Consultation response from Economic Regeneration.

APPLICATION NO: BR/170/13/

Site Address: The Esplanade opposite Cavindish House Bognor Regis PO21 1NA

Description of Works: The proposed works consists of monitoring and recording wastewater flows from the combined sewerage system where they spill to the environment. Level monitoring equipment is placed within a Combined Sewer Overflow (CSO) manhole and together with recording equipment housed within a GRP roadside kiosk, data is transmitted via telemetry to SWS. Erection of a permanent roadside monitoring kiosk (1250mm h x 1150mm w x 500mm d).

| DRAWING TITLE<br>CSO & EMO KIOSK TEMPLATE<br>EXTERNAL LAYOUT |  |  |  |

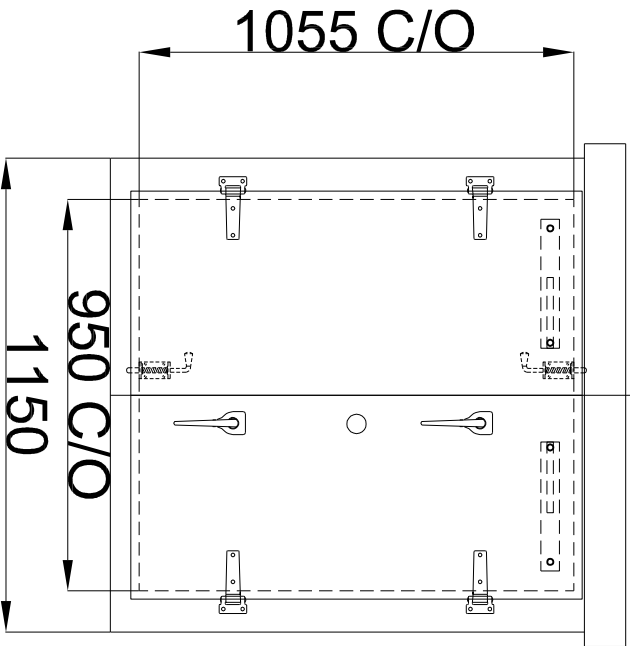
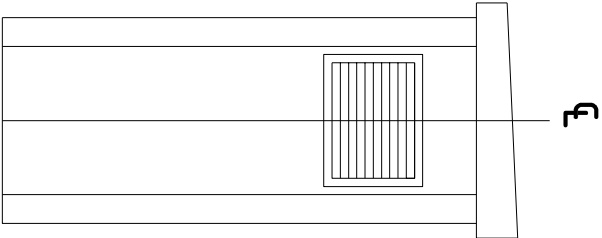
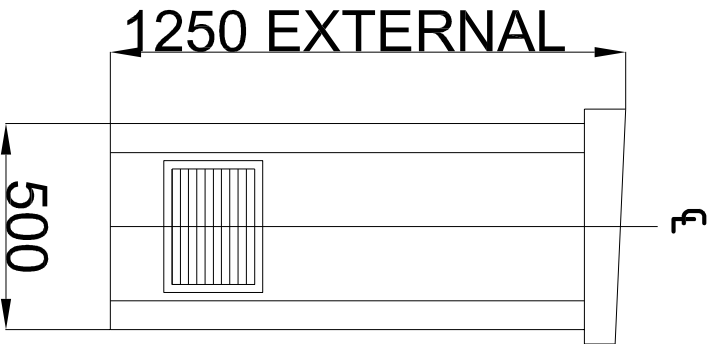
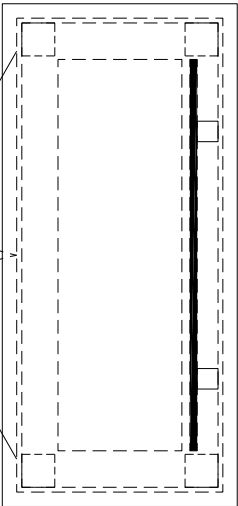
We would strongly object to both the location and the design of this equipment. The current location is in an area that is likely to be redeveloped in line with the Council's Seafront Strategy. The aim of the Strategy is to make the seafront a more attractive place for visitors, this equipment will do nothing towards that aim.

ESPLANADE BOGNOR CSO **SITE AND LOCATION PLAN**

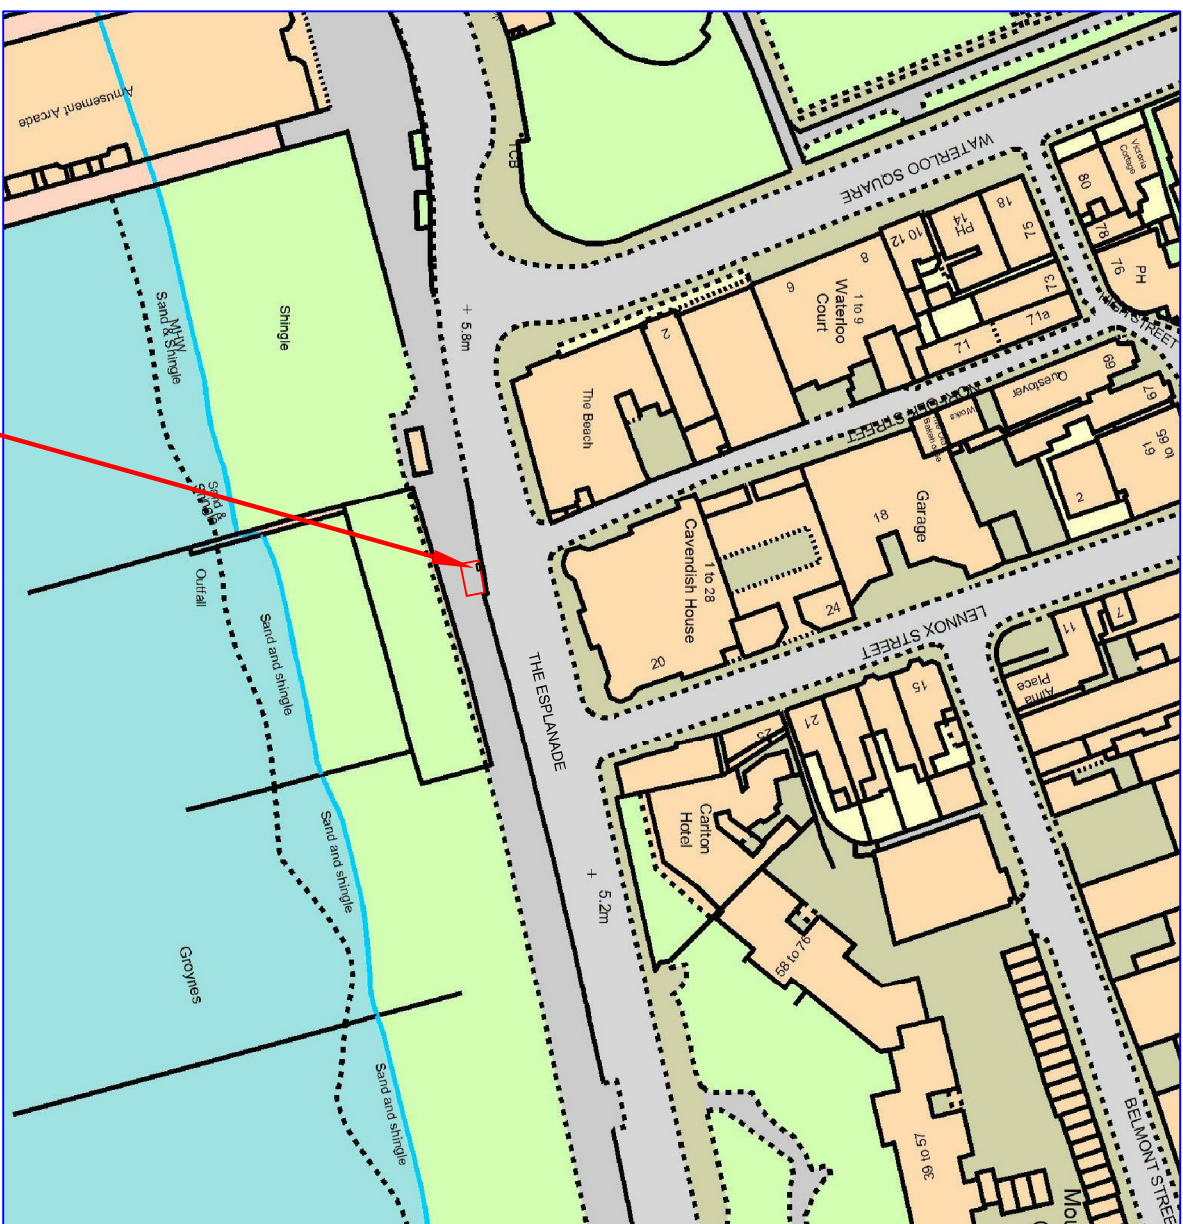
We would suggest that a better location would be on the western side of the Pier, in a less visually obvious position.
